ROLLIN RIDGE Filing No. 1 Construction Drawings El Paso County, Colorado

ROLLIN RIDGE - FILING NO. 1

Construction Drawings_V1.pdf Markup Summary

SHEET: **G2**

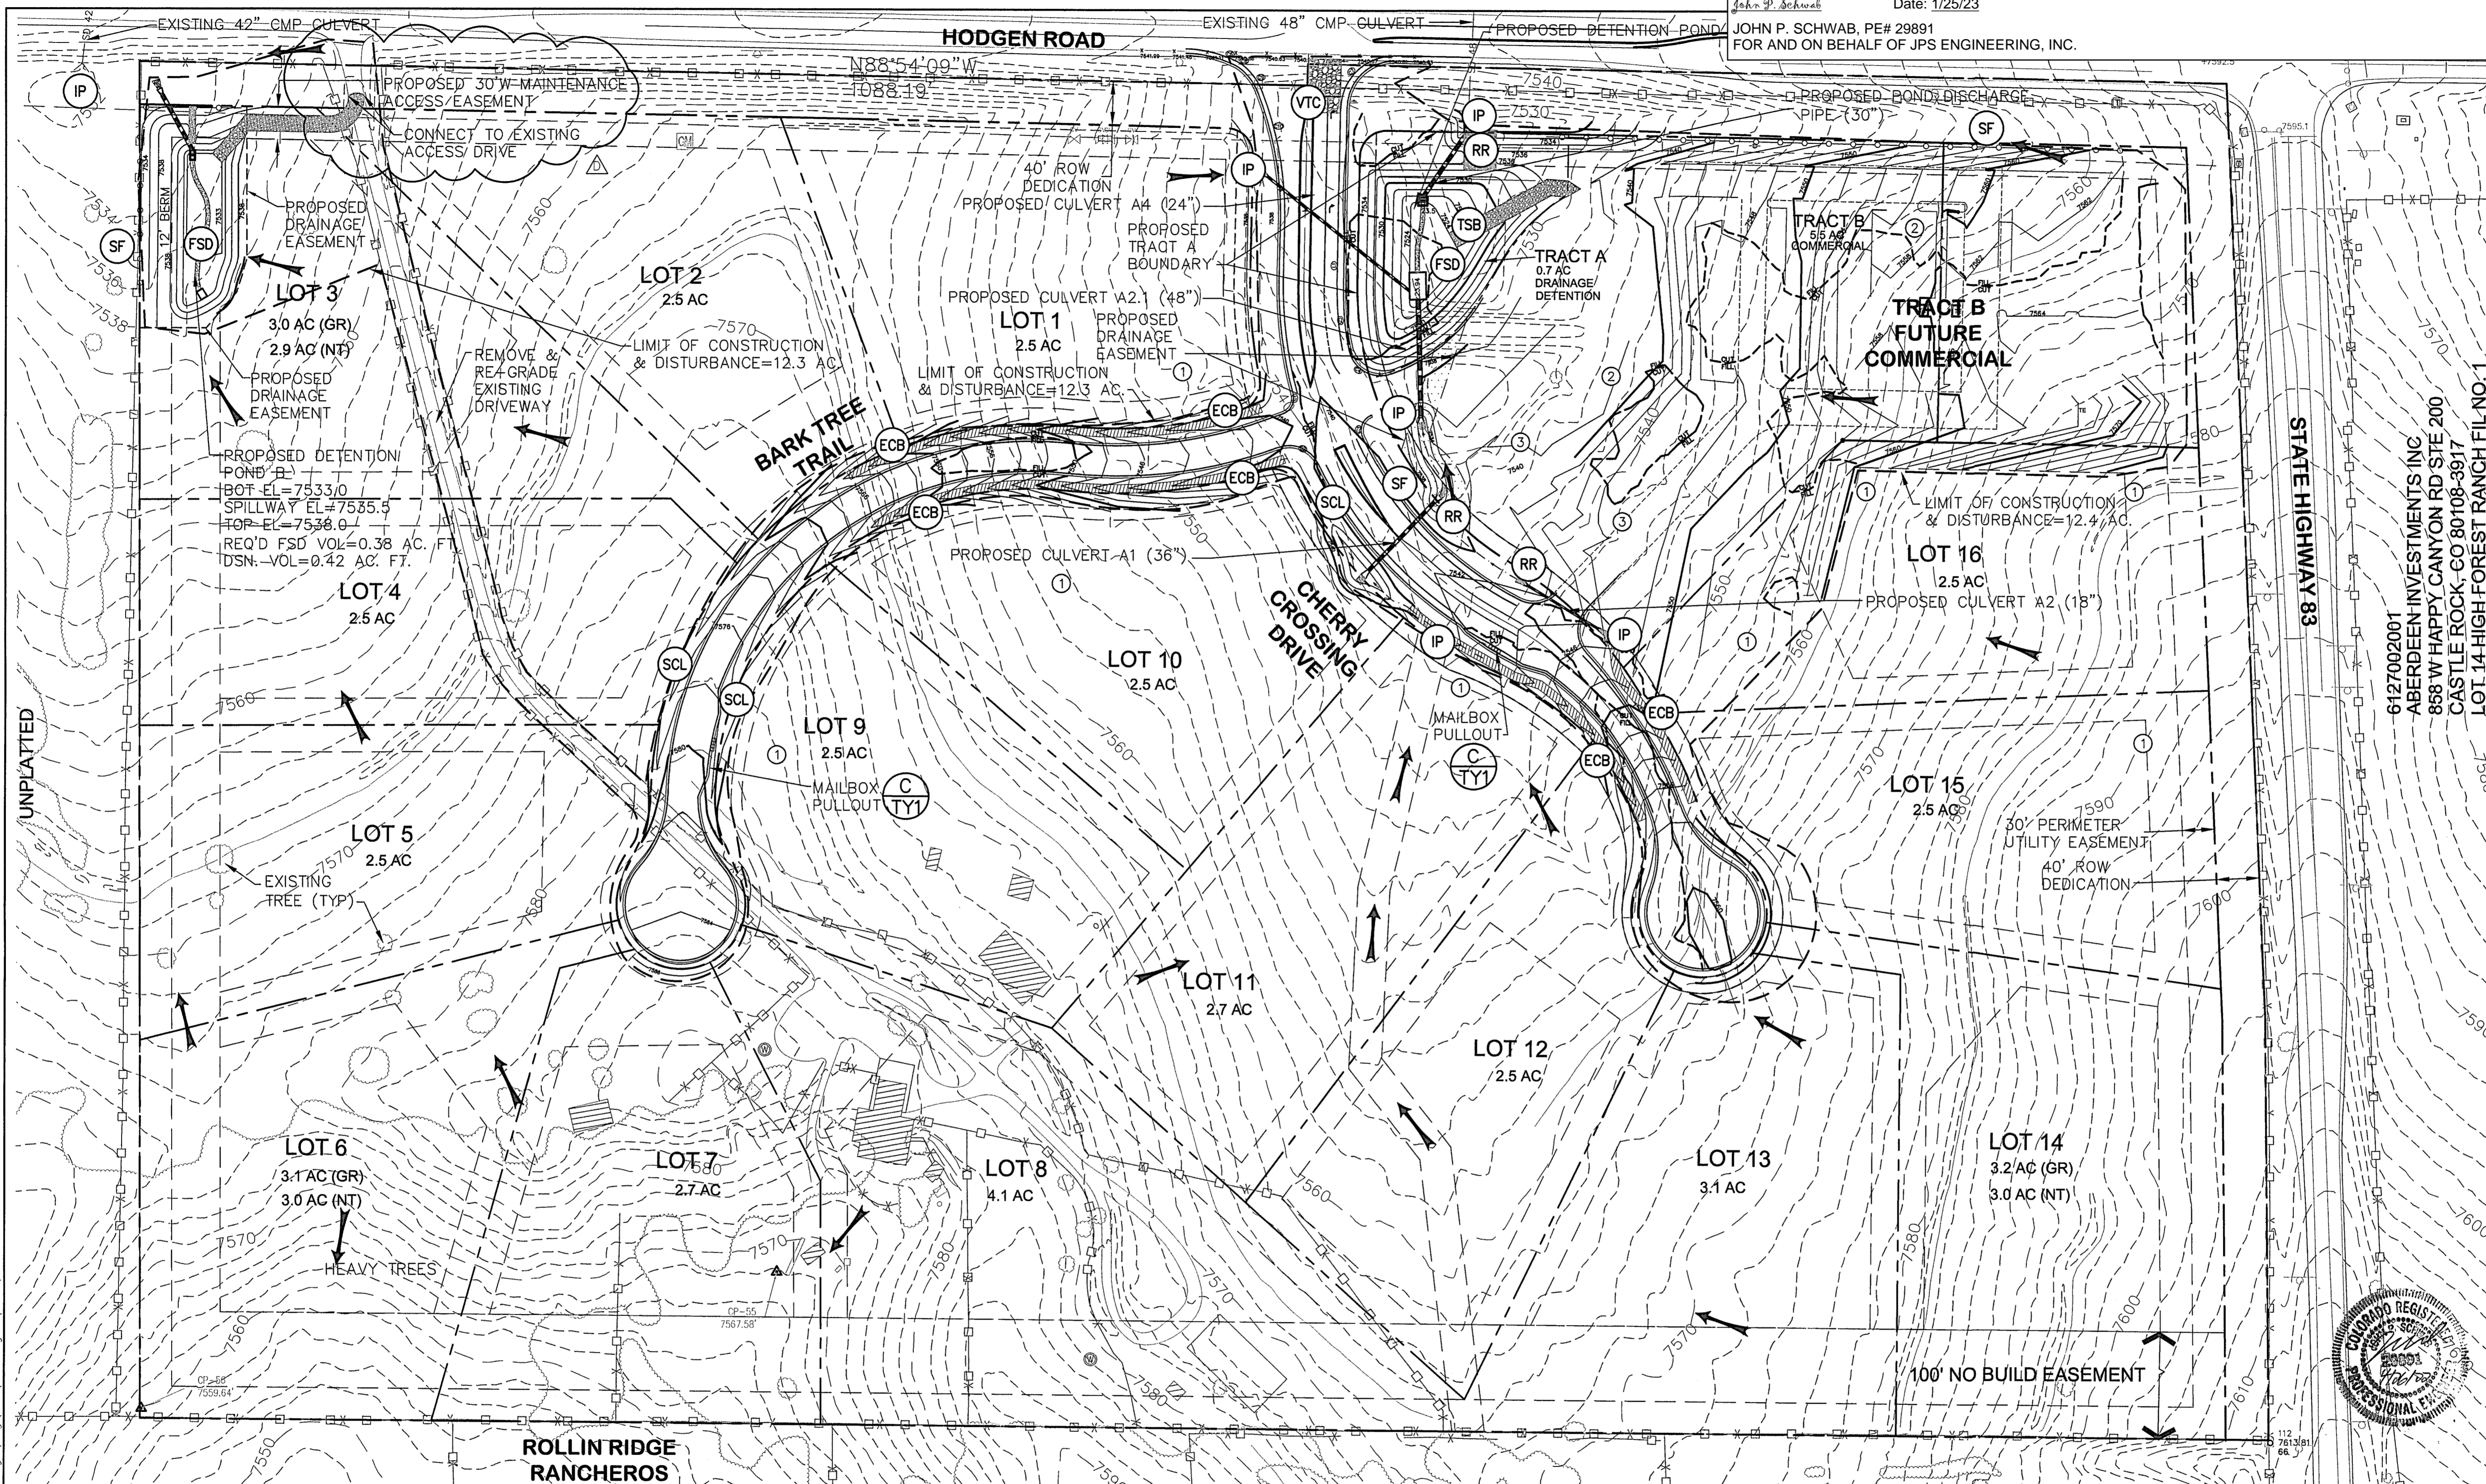
Update all reference
from DSD to PCD

TY1

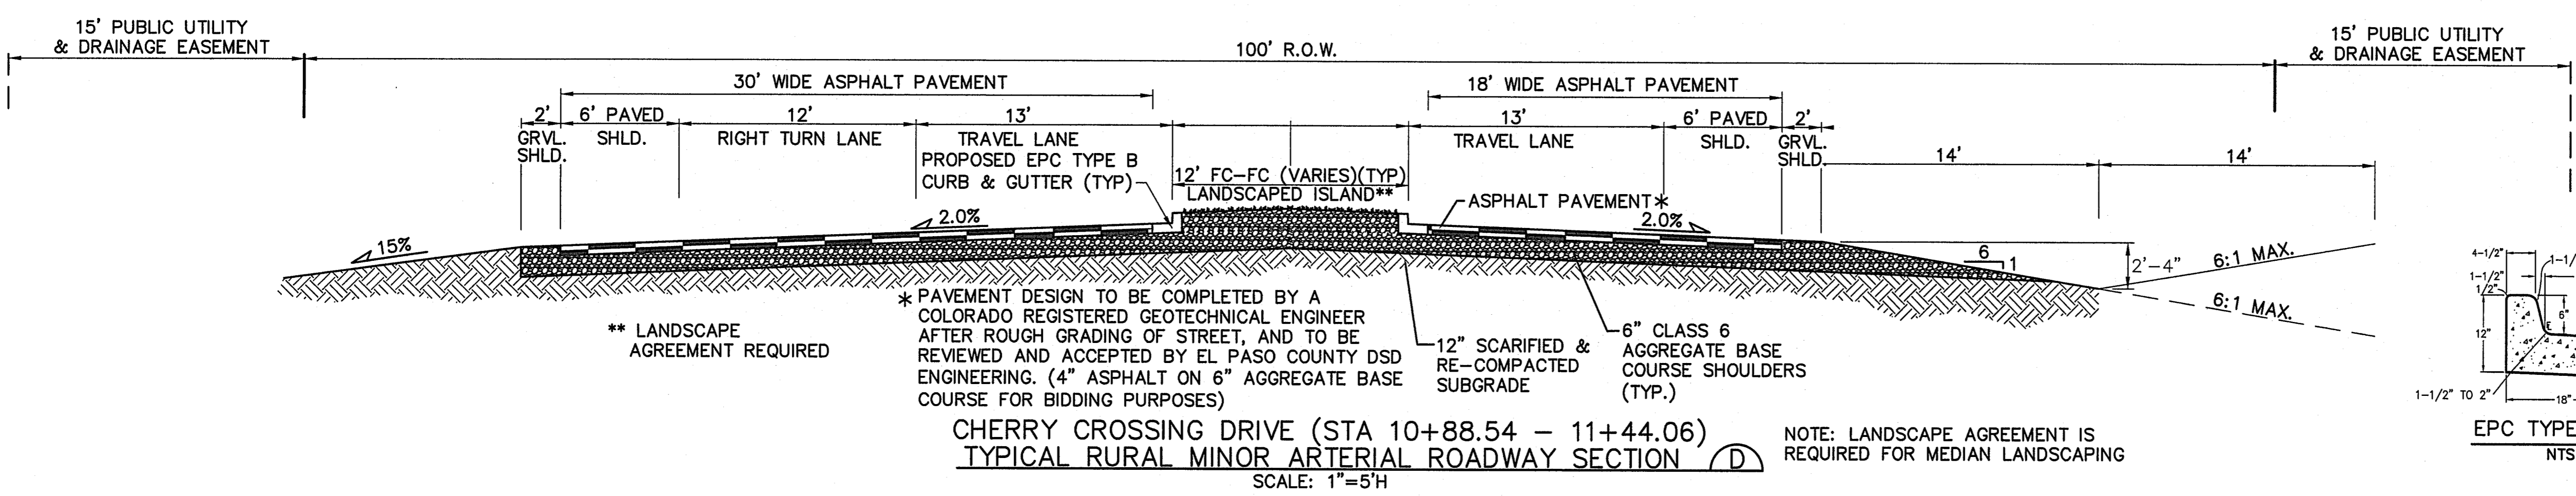
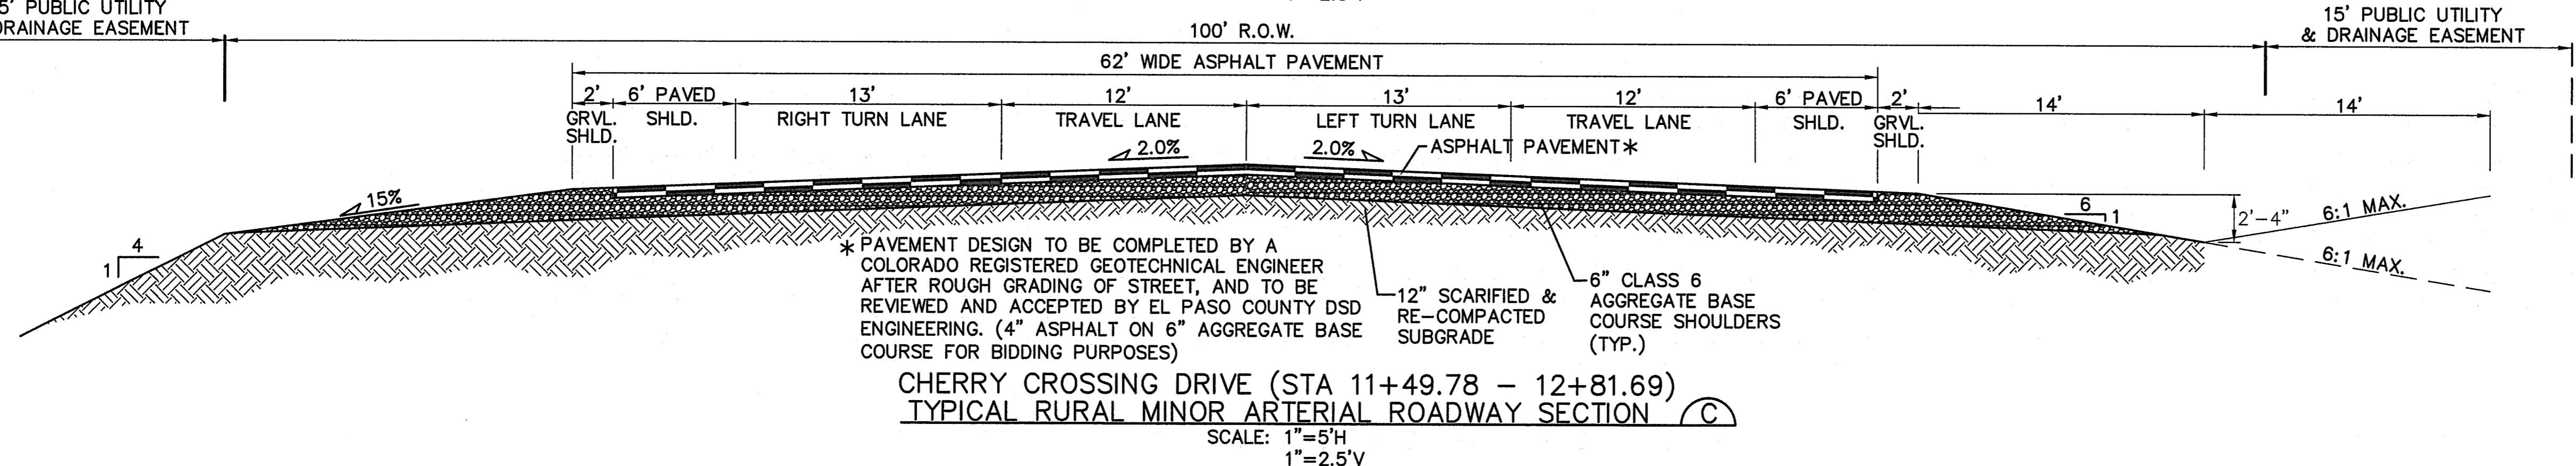
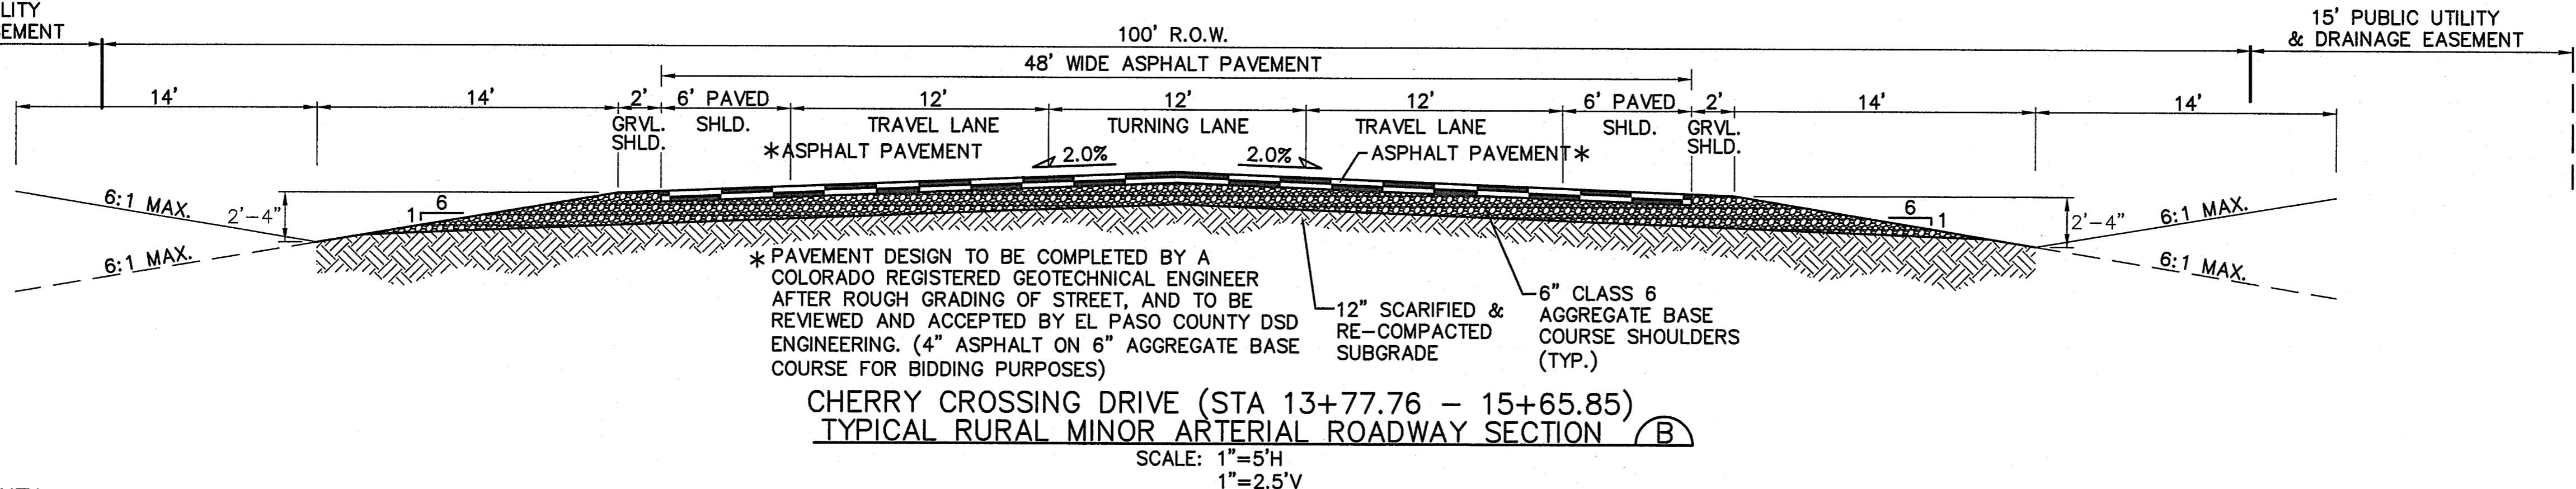
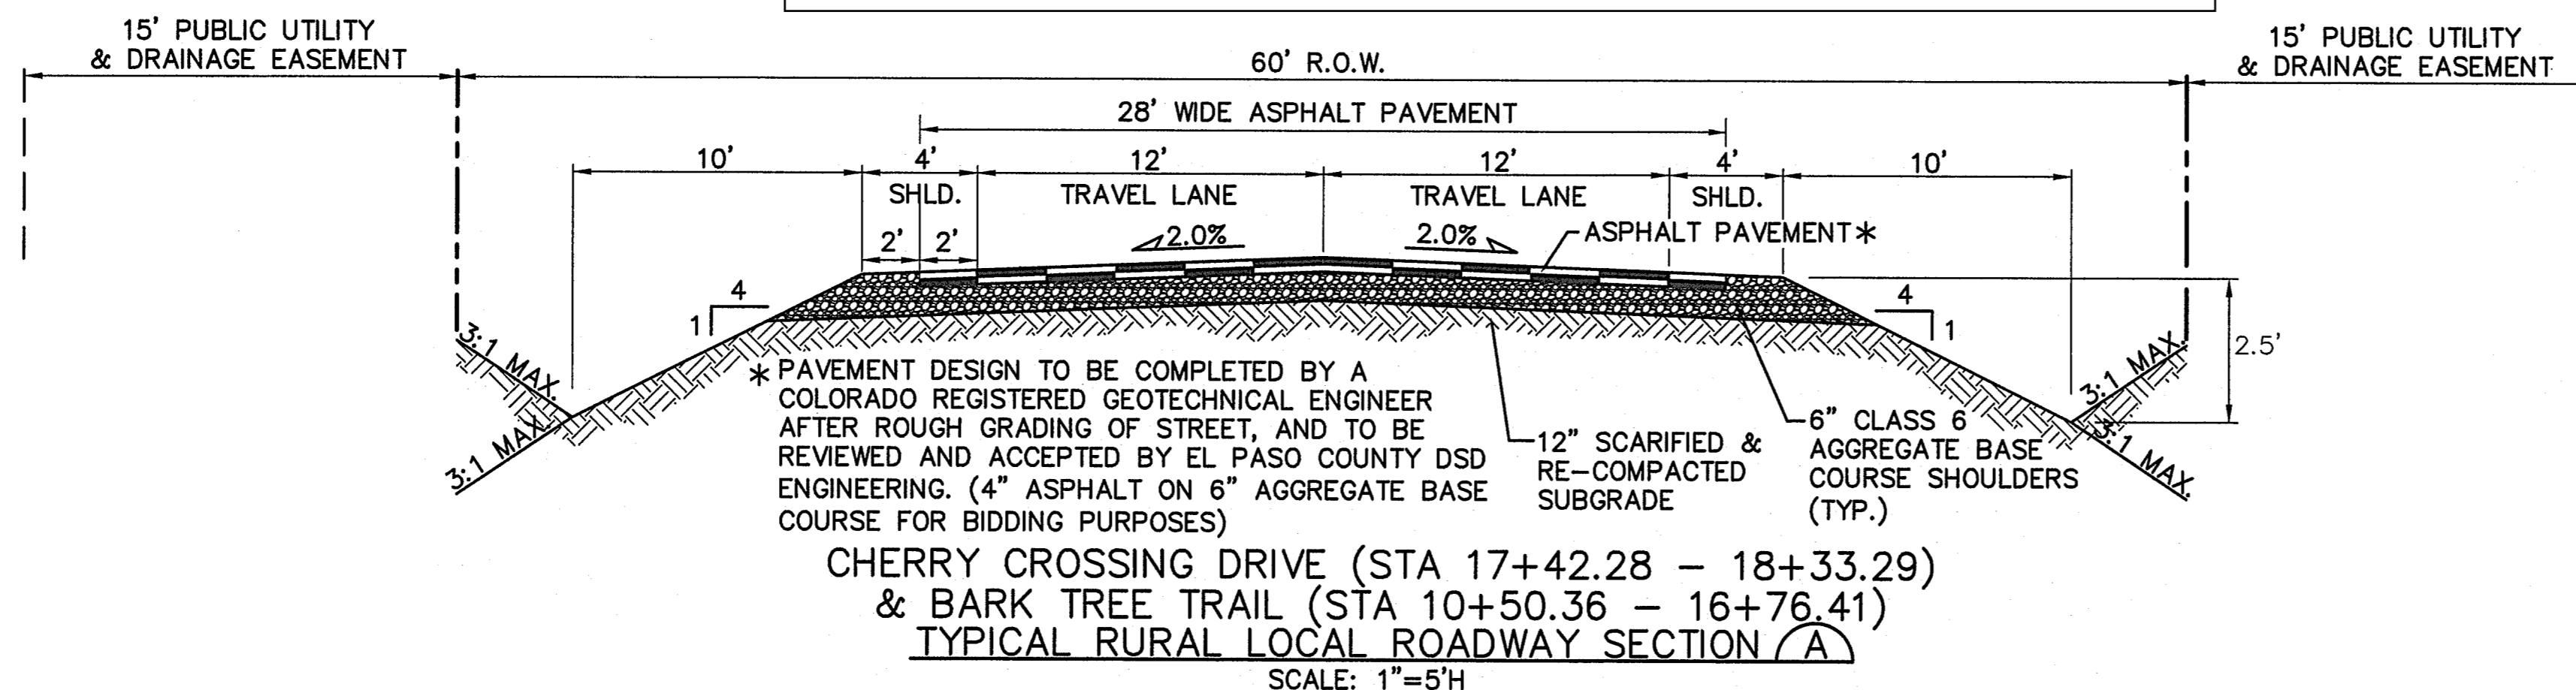
Include a public improvement easement per the rural local roadway standard cross section SD_2-11. (FYI: The detail only requires 5' for the Public Improvement Easement).

Coordinate with the surveyor to also reflect on the plat.

Update all label on the back slope to 3:1 Max

Include the applicable street.

Revise k value. The deviation request with the preliminary plan was for a design speed of 30 mph.
